The Planning Inspectorate

Date: 17 July 2024

Application by Rampion Extension Development Limited for an Order Granting Development Consent for the Rampion 2 Offshore Wind Farm Project

Request for Additional Information

Figure 5-14 Zoning Plan: Piling Restriction for period 1<sup>st</sup> March to 30<sup>th</sup> June

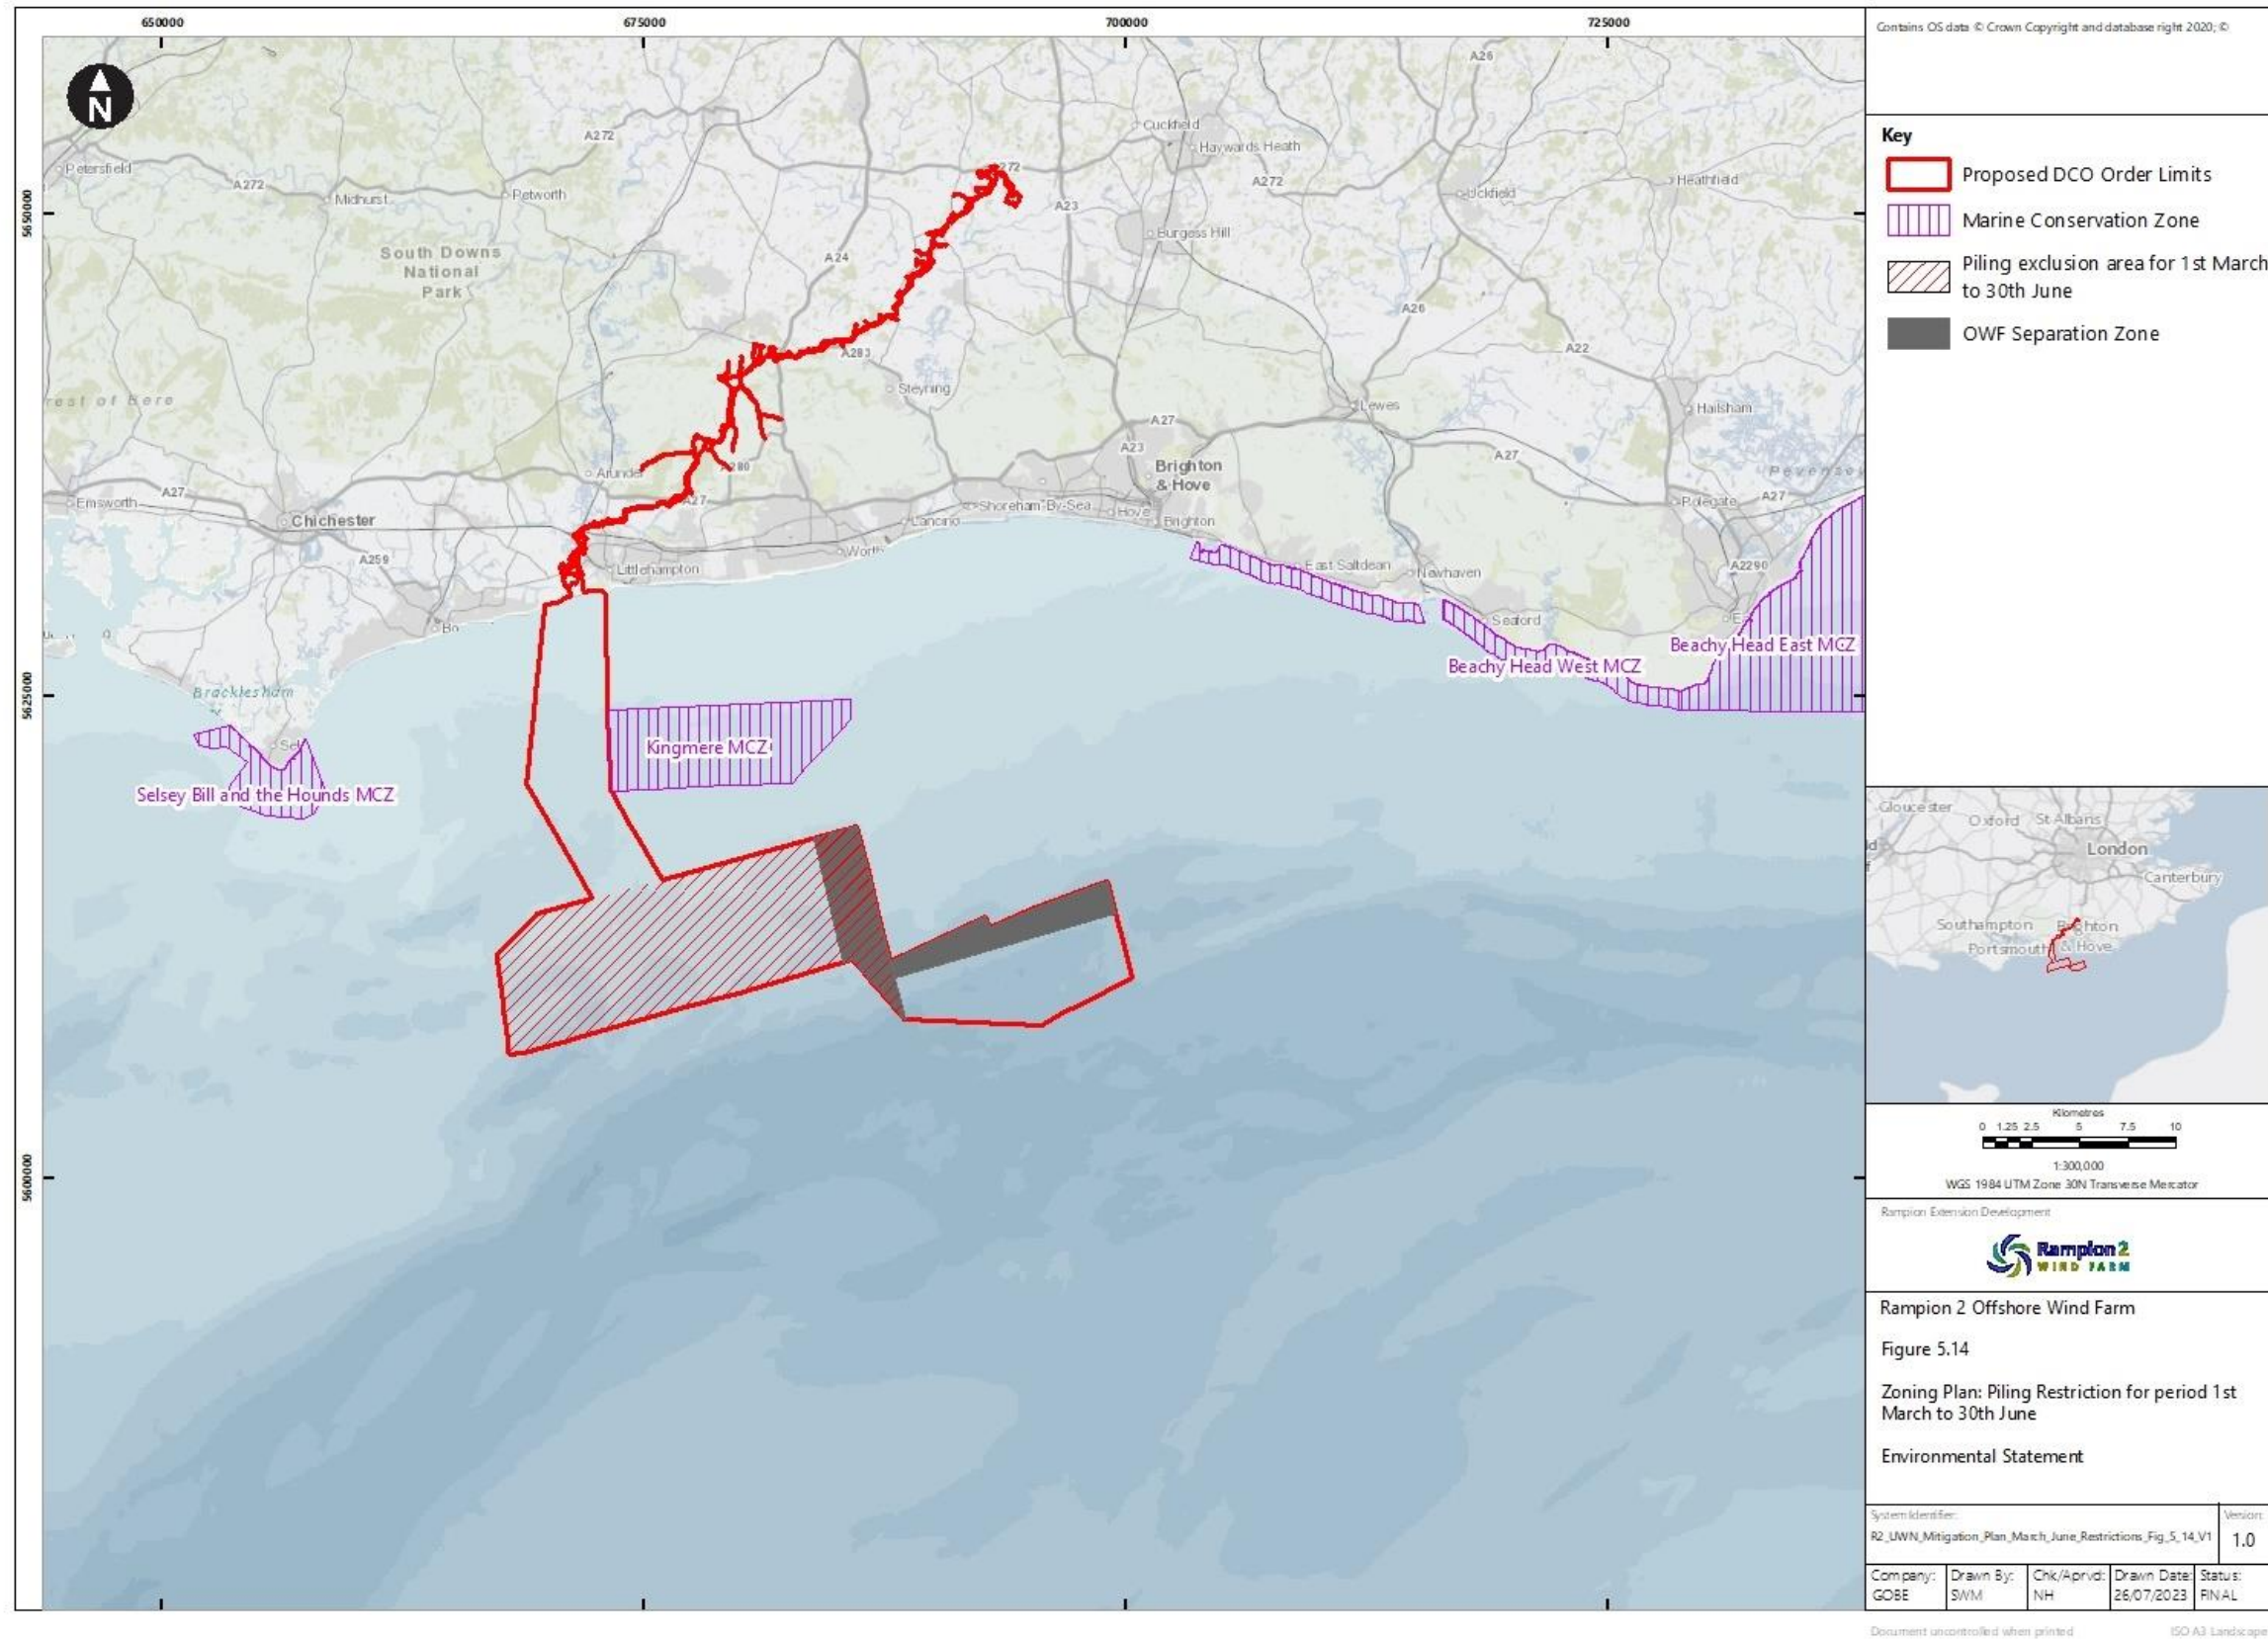
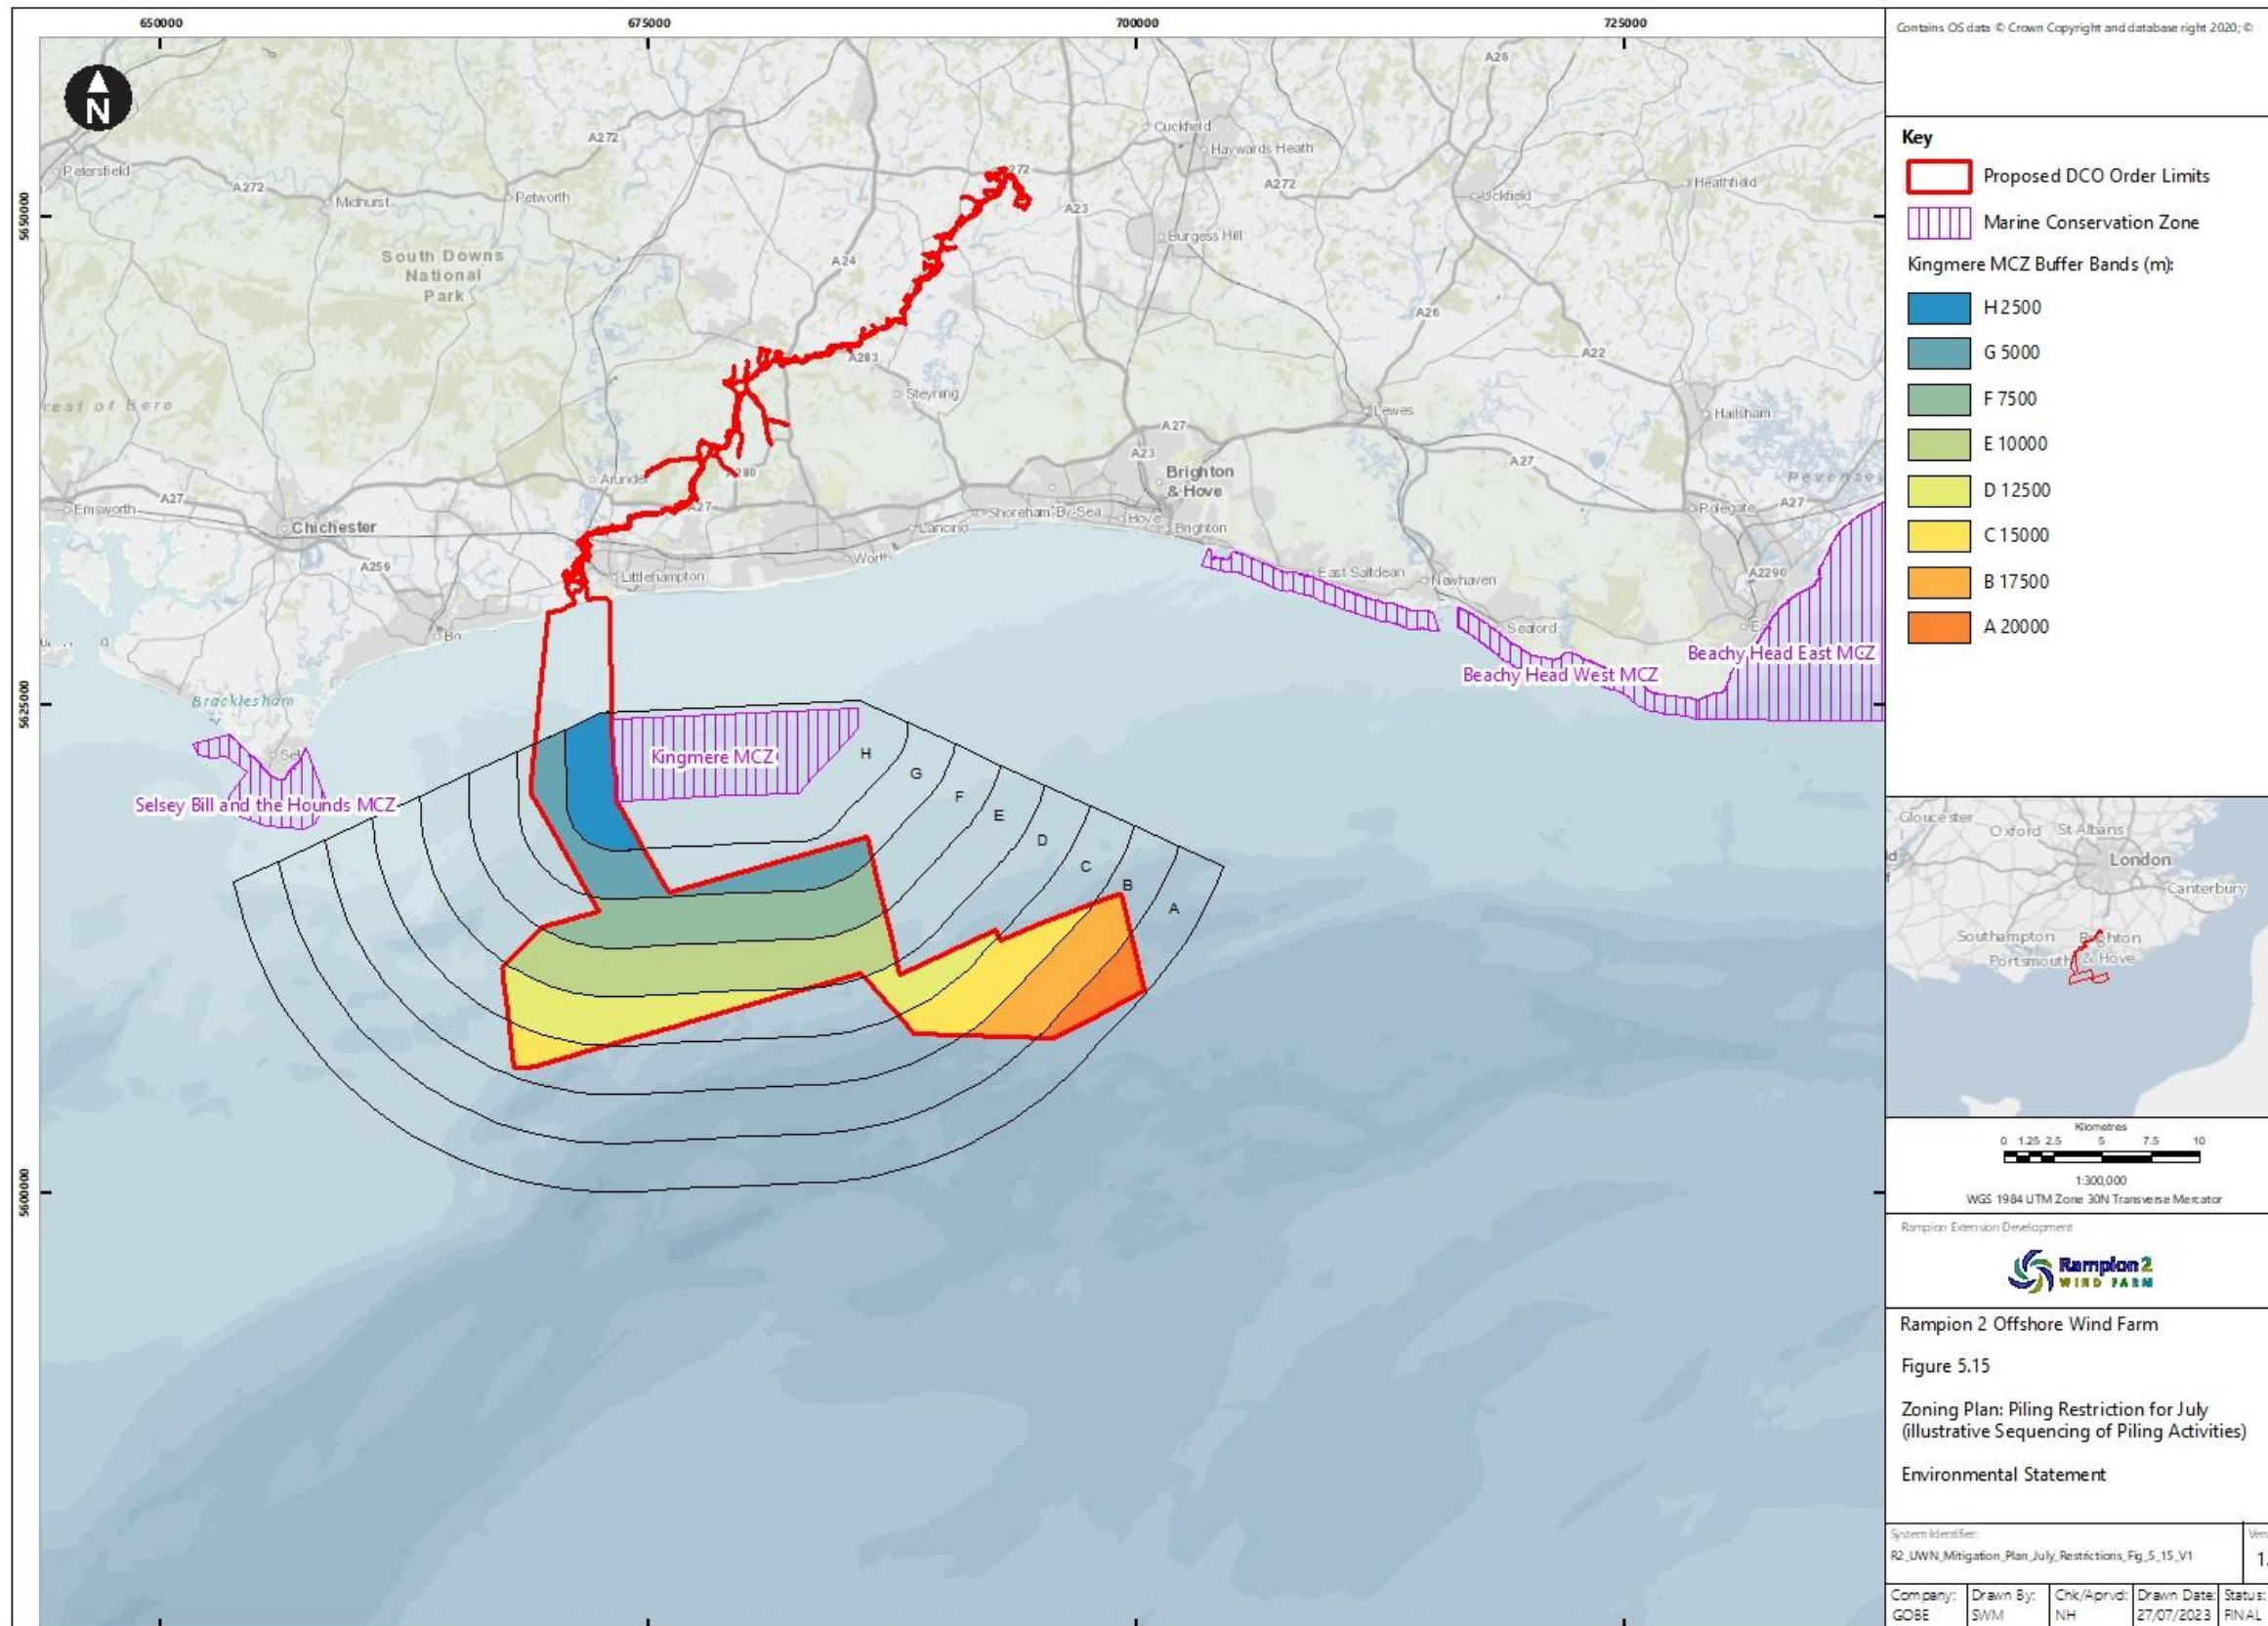
4.	NEW	<i>Notwithstanding the mitigation measures proposed within the submitted information and the Commitment Register, there shall be no piling associated with this development between the dates of 01 March to 31 July inclusive, unless otherwise agreed in writing before the commencement of any piling by the Marine Management Organisation</i>	<p>Natural England have requested this restriction based on the potential impact of underwater noise from piling on Black Seabream during their breeding/nesting season within the Kingmere MCZ.</p> <p>The Applicant is requested to comment on this potential additional condition and its wording, should the Secretary of State decide that it is required within the Deemed Marine Licences.</p>
